Letter of Intent / Narrative for a zoning code review

From: Kenneth Trujillo
Subject: DN03486D - T-Mobile Back Up Generator Addition
Date: 5/23/2022
Location: 9285 Drennen Road Colorado Springs, CO 80925
Latitude: 38°46'48.55" N Longitude: 104°39'20.17" W
Parcel #: 55031-19-017

SHEET NUMBER:  
**T1**

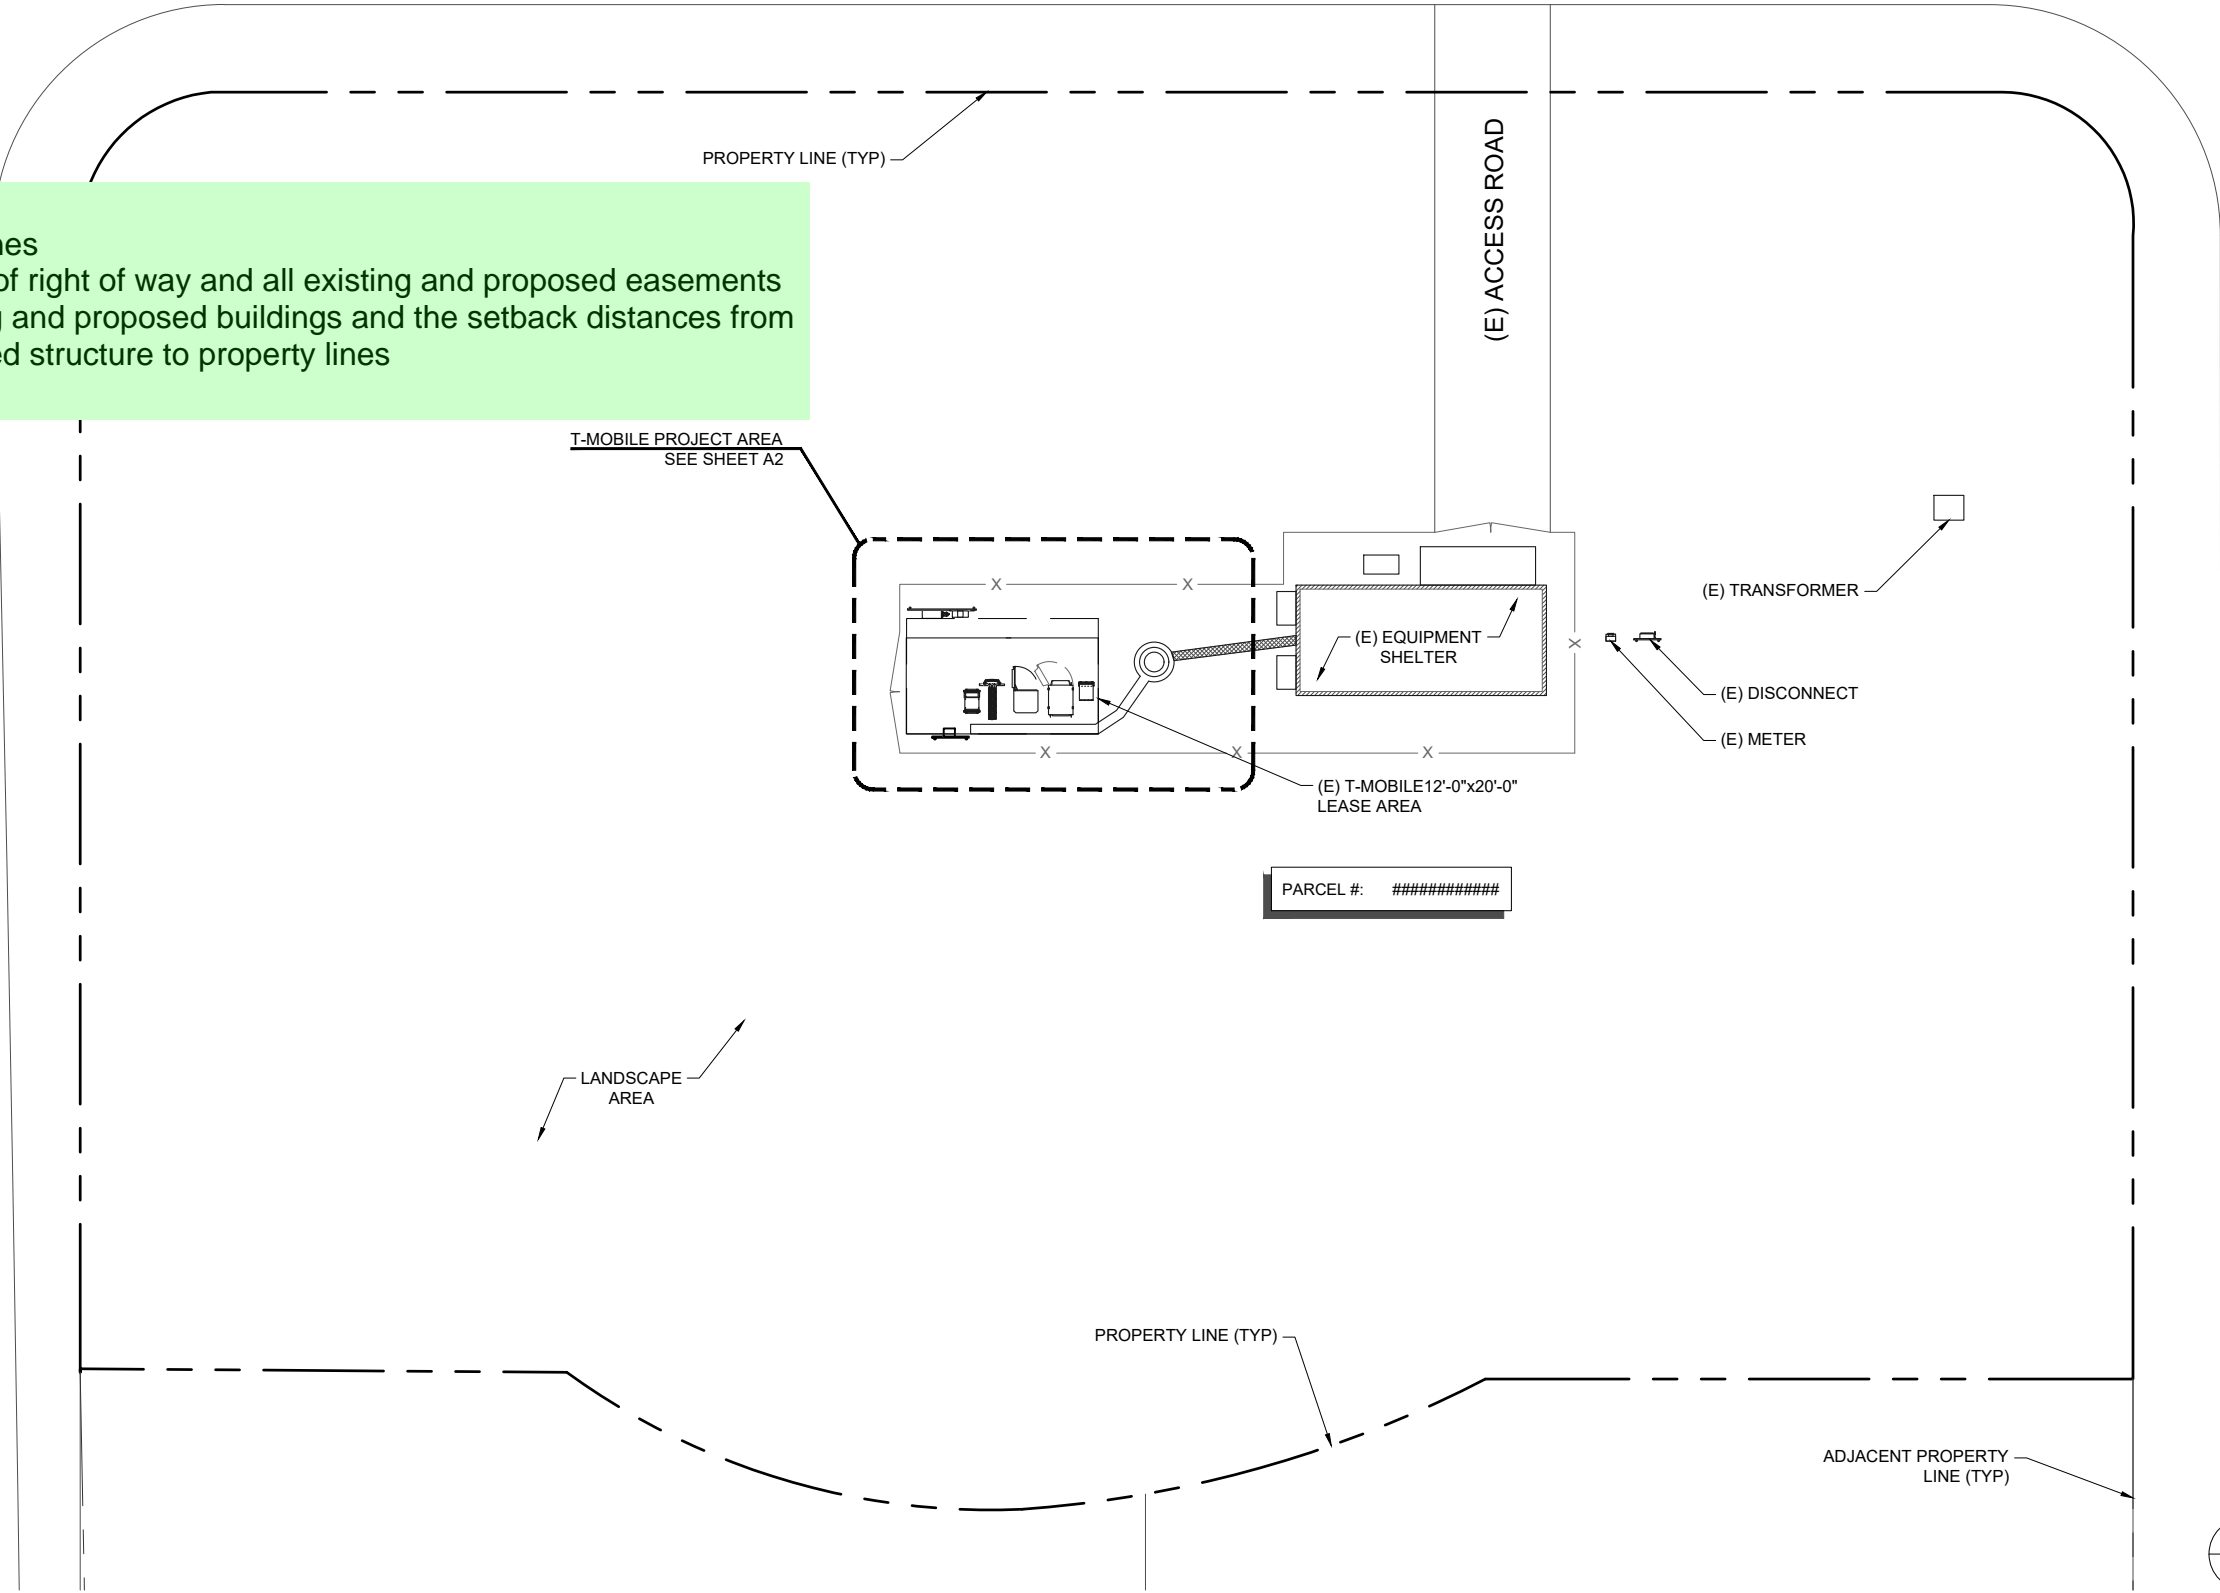
Please include:
-current zoning of the property
-a discussion summarizing the proposed request
and how it meets the LDC requirements
